Re: Certification Submittal for Final Building Certificate of Occupancy for  
Arapahoe Drilling Office Warehouse Bldg, [C-16 / D6SS]  
8532 Calle Alameda NE  
Architect's Stamp Dated 11/07/07

**Re: Arapahoe Drilling, 8532 Calle Alameda, (C-16/D006SS)**  
**Approval of Permanent Certificate of Occupancy,**  
**Engineer's Stamp Date 4/26/2007**  
**Certification dated: 1-2-08**

**Re: Arapahoe Drilling, 8532 Calle Alameda, (C-16/D006SS)**

**Re: Arapaho Drilling, 8532 Calle Alameda**  
**Grading and Drainage Plan**  
**Engineer's Stamp dated ~~3-19-07~~ (C16/D006SS)**  
**4-26-07**

ARAPAHO DRILLING
GRADING AND DRAINAGE PLAN

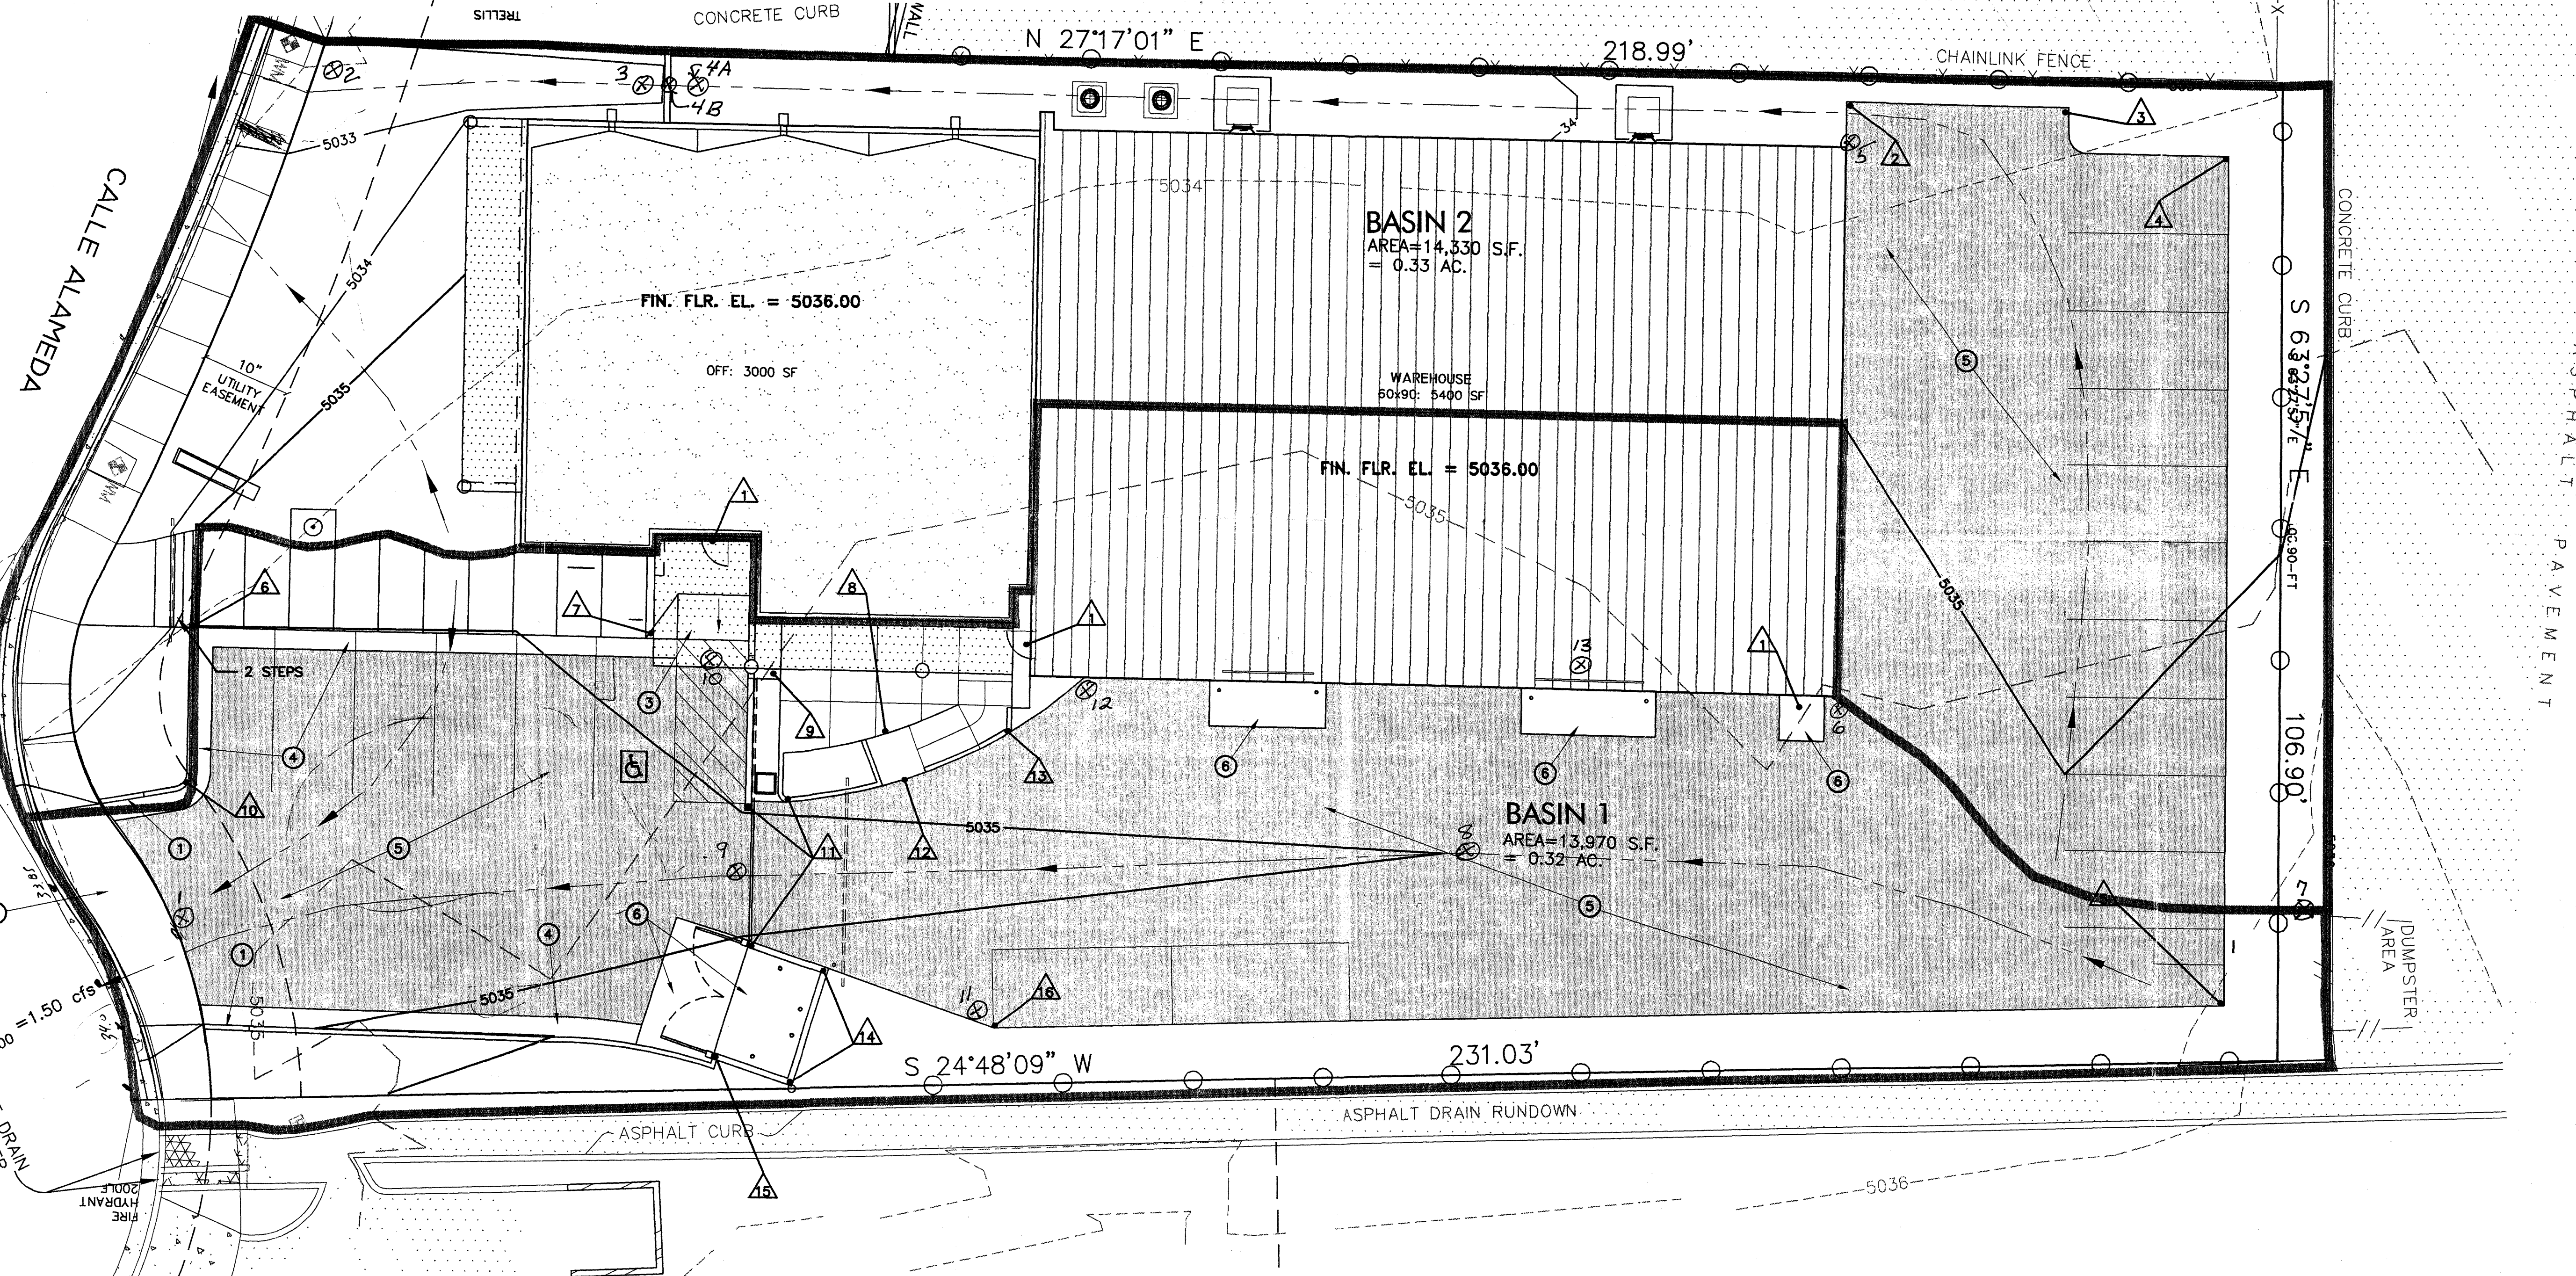
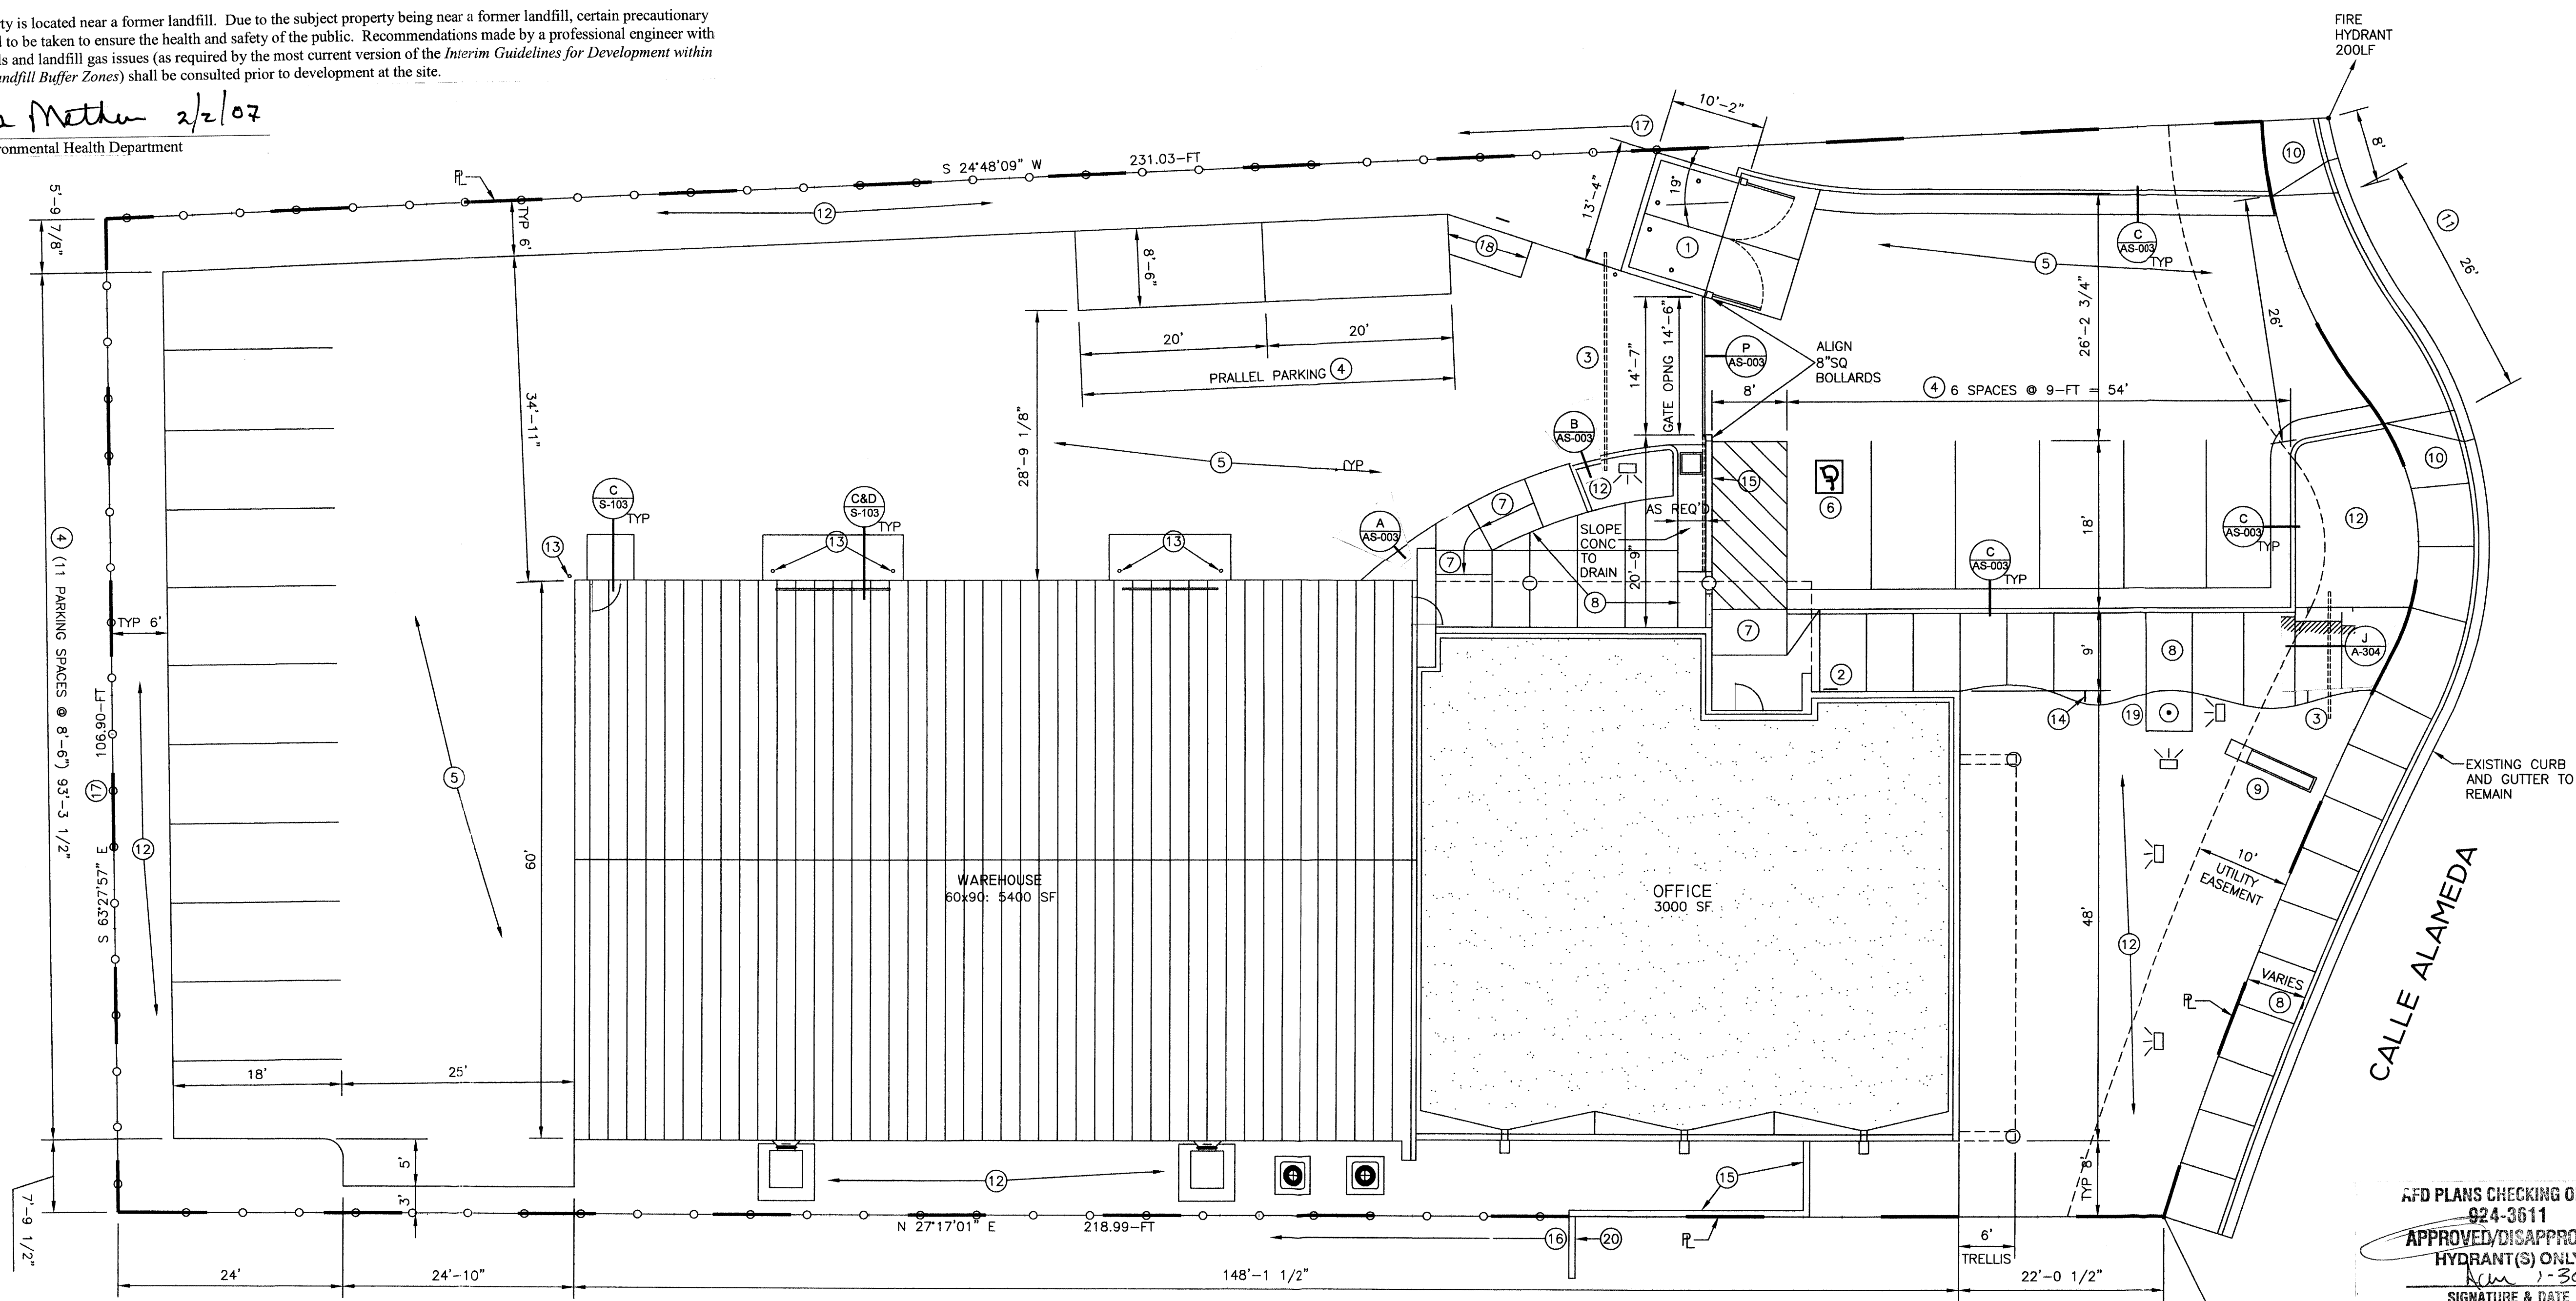
- The approved plan, dated 4-26-07, will need to be certified with the enclosed sample certifying letter. This is the language that needs to be on the plans with the Engineer's Certification, it also needs to be stamped, signed, and dated.
